211813 CFAA

## Modification 7 Precinct Village and Carpark (SSD-9835-Mod-7)

### Technical Note on Flooding in Response to DPE Comments

Legend

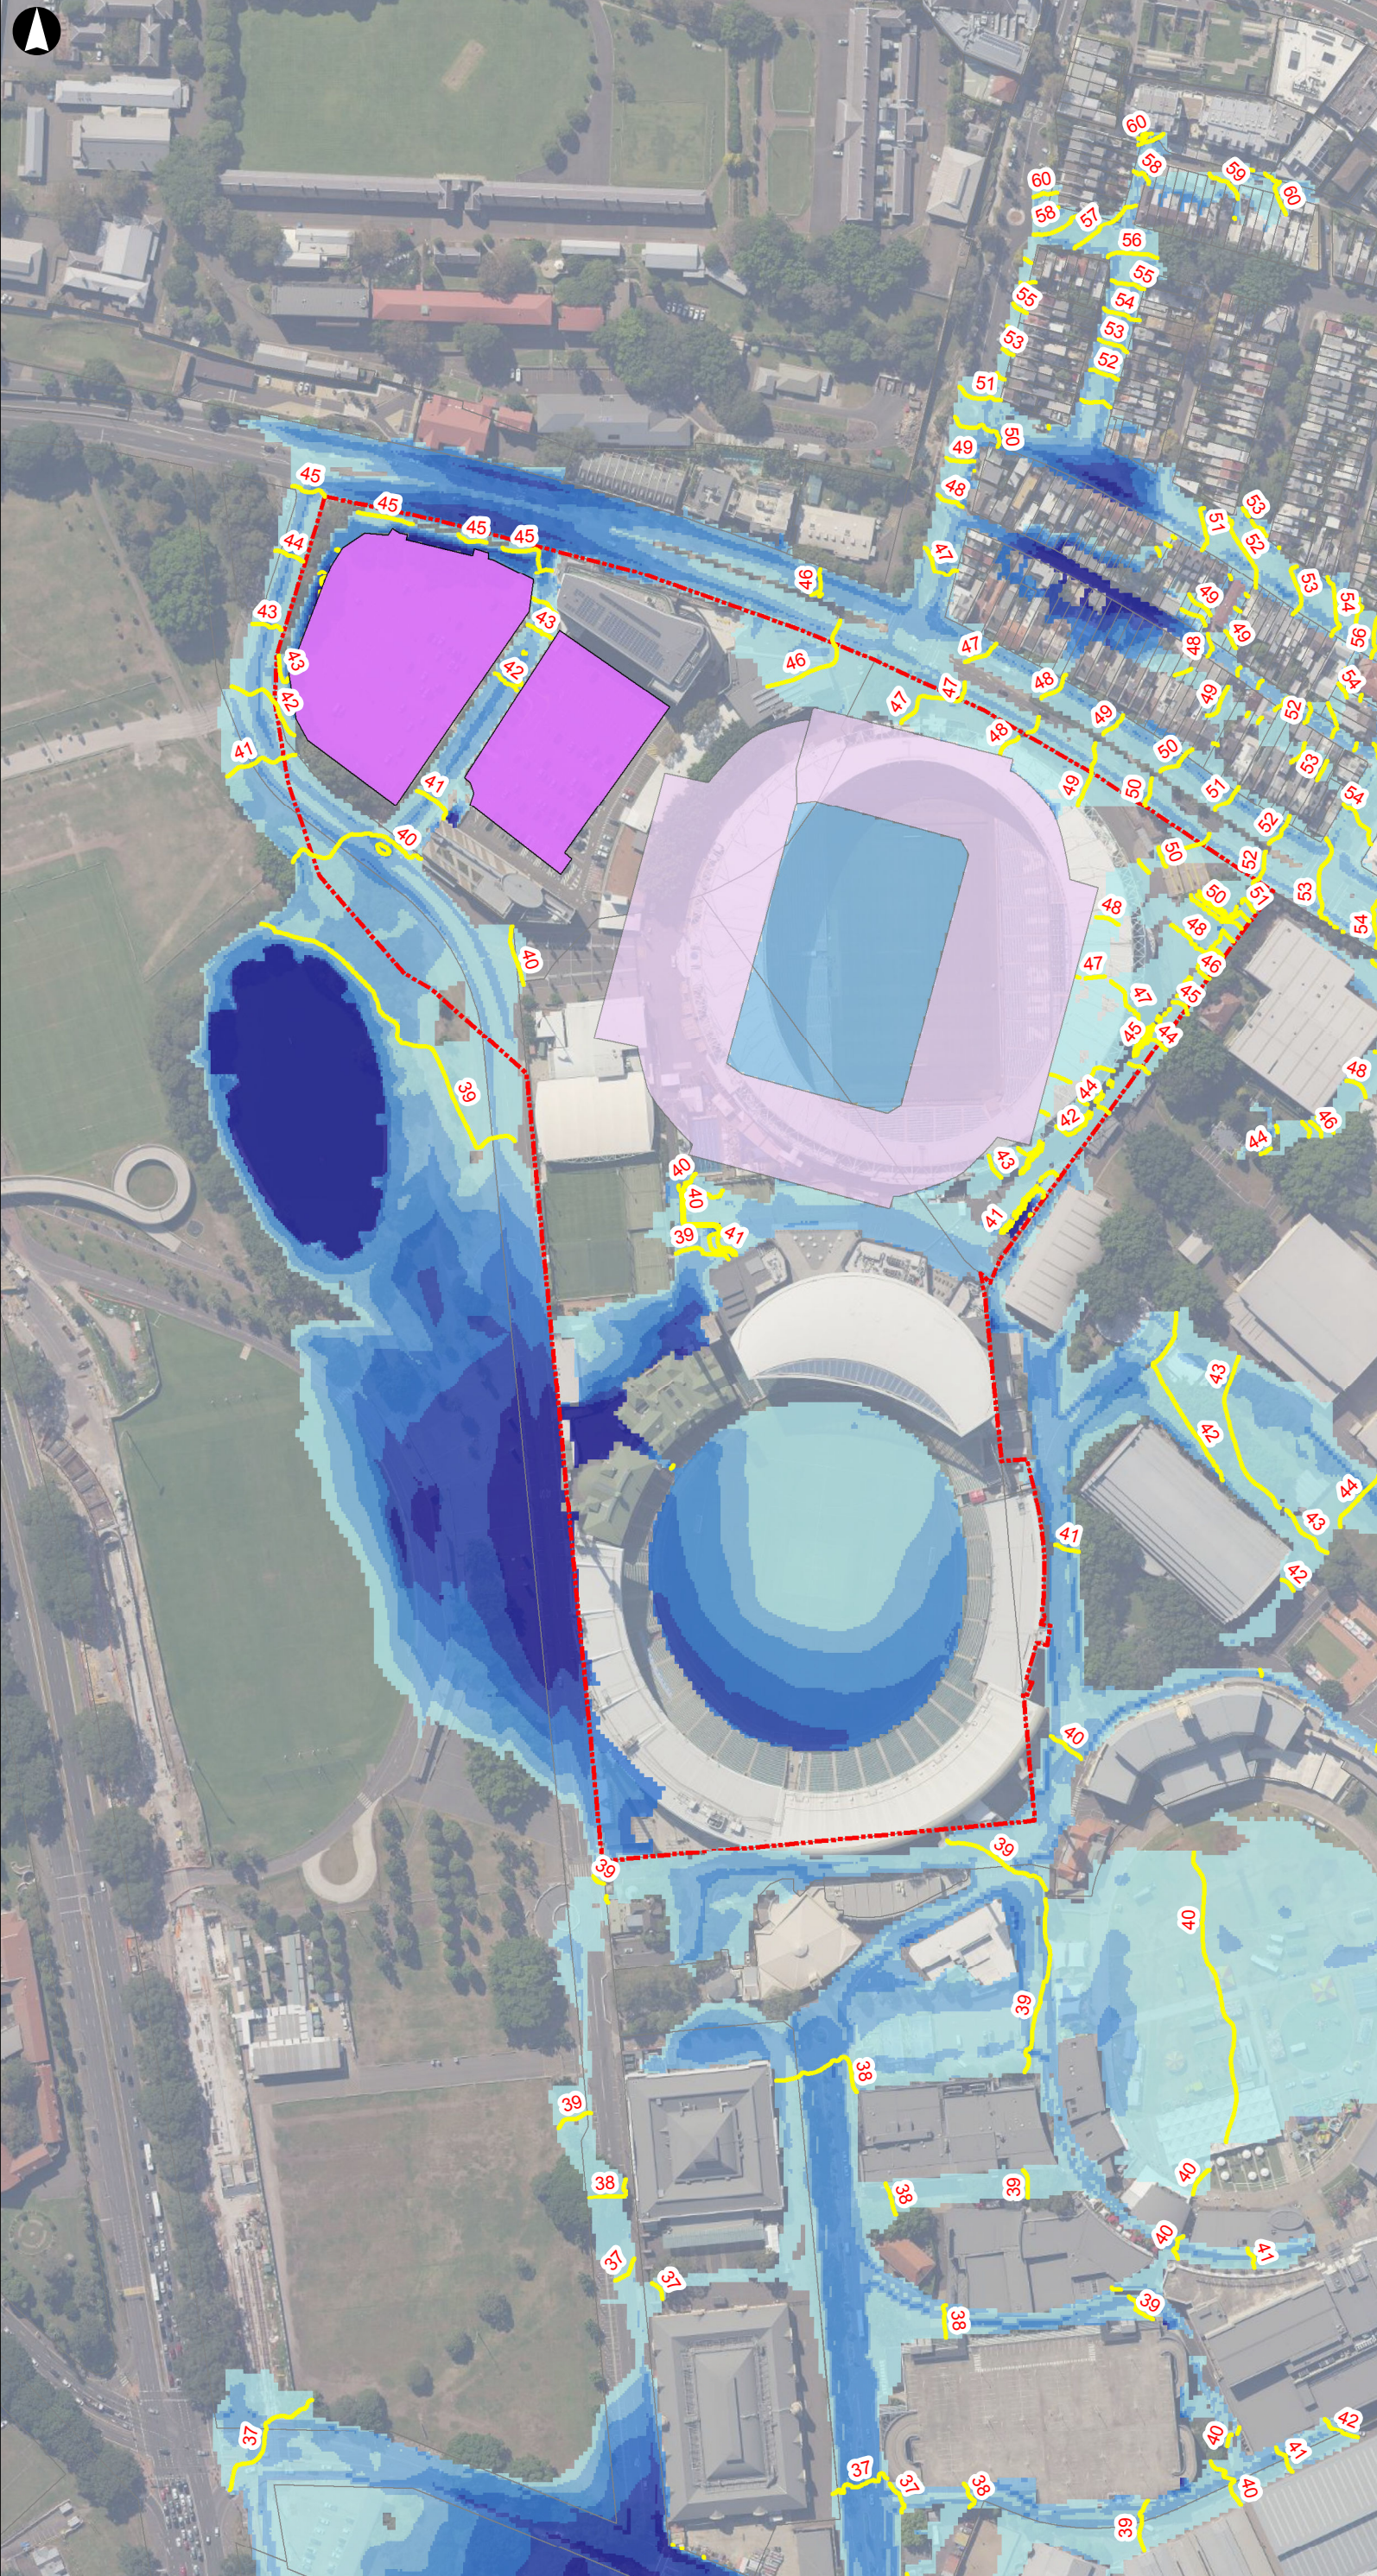
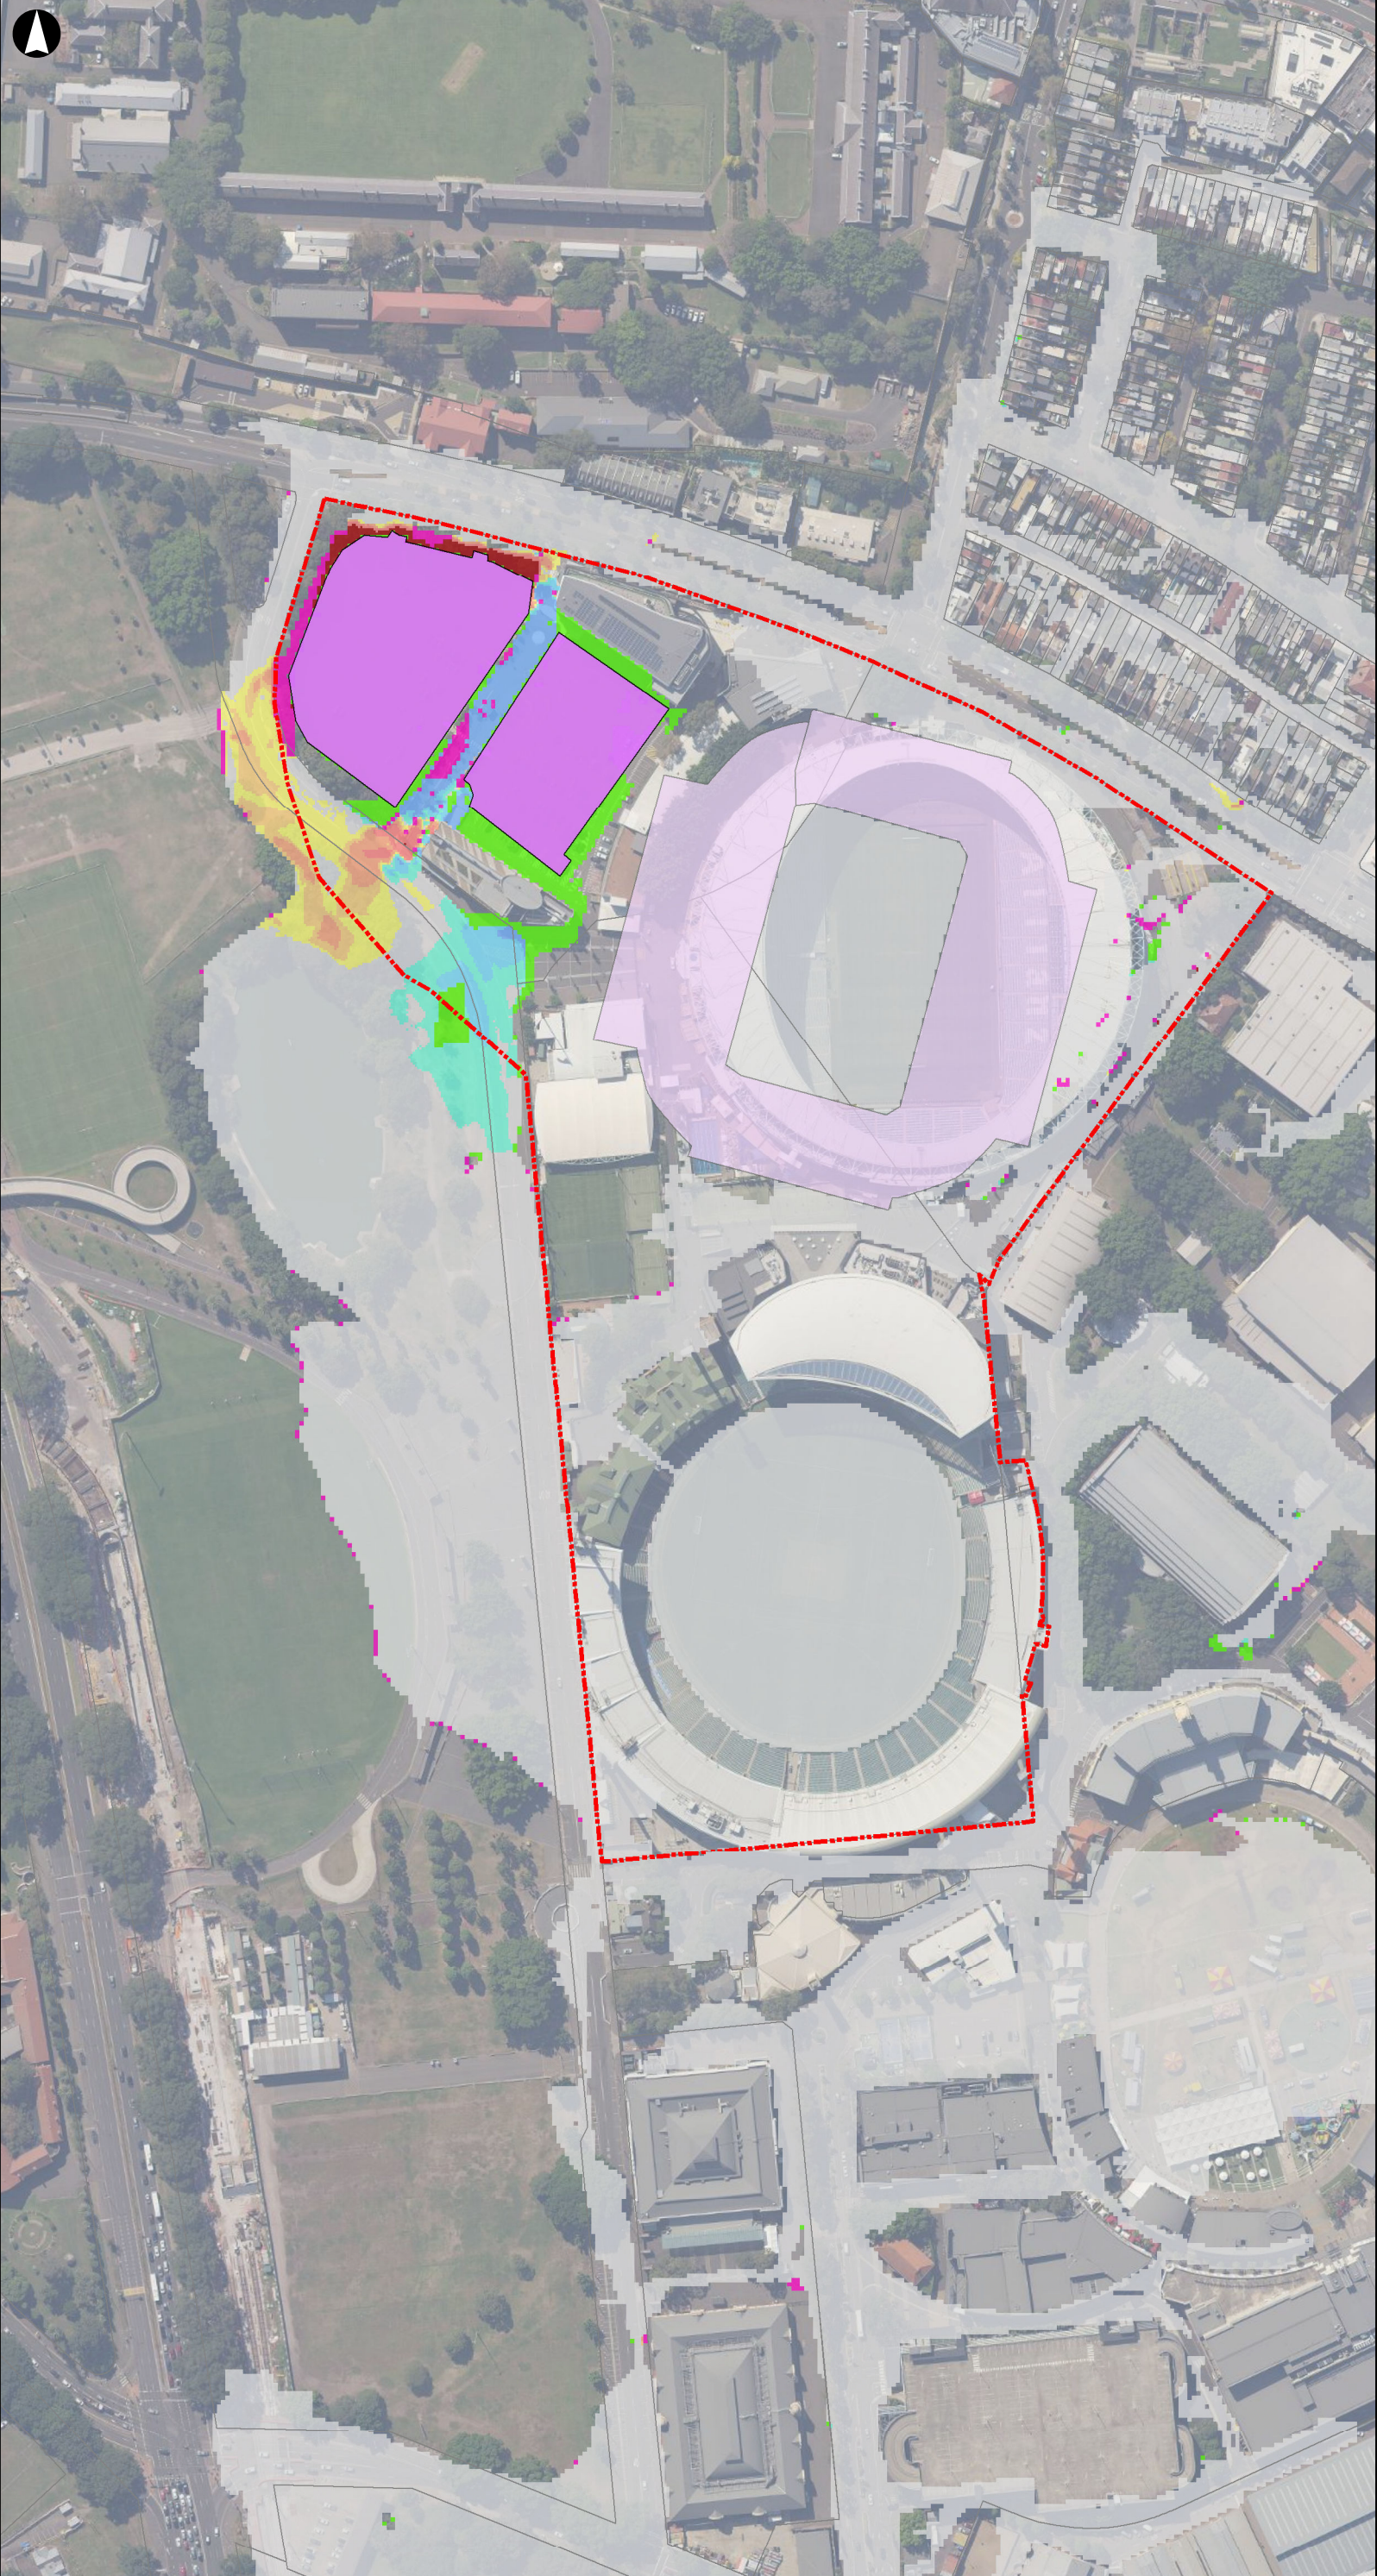
- there are only three figures presented in Appendix G, presumably showing hazard. The RtS states afflux figures were provided, but they are not available at Appendix G. Figures as per the original report should be updated, including depth/level and afflux

Additional figures have been included in section 4.0 that show flood levels, depths, hazard and afflux associated with the proposed development.
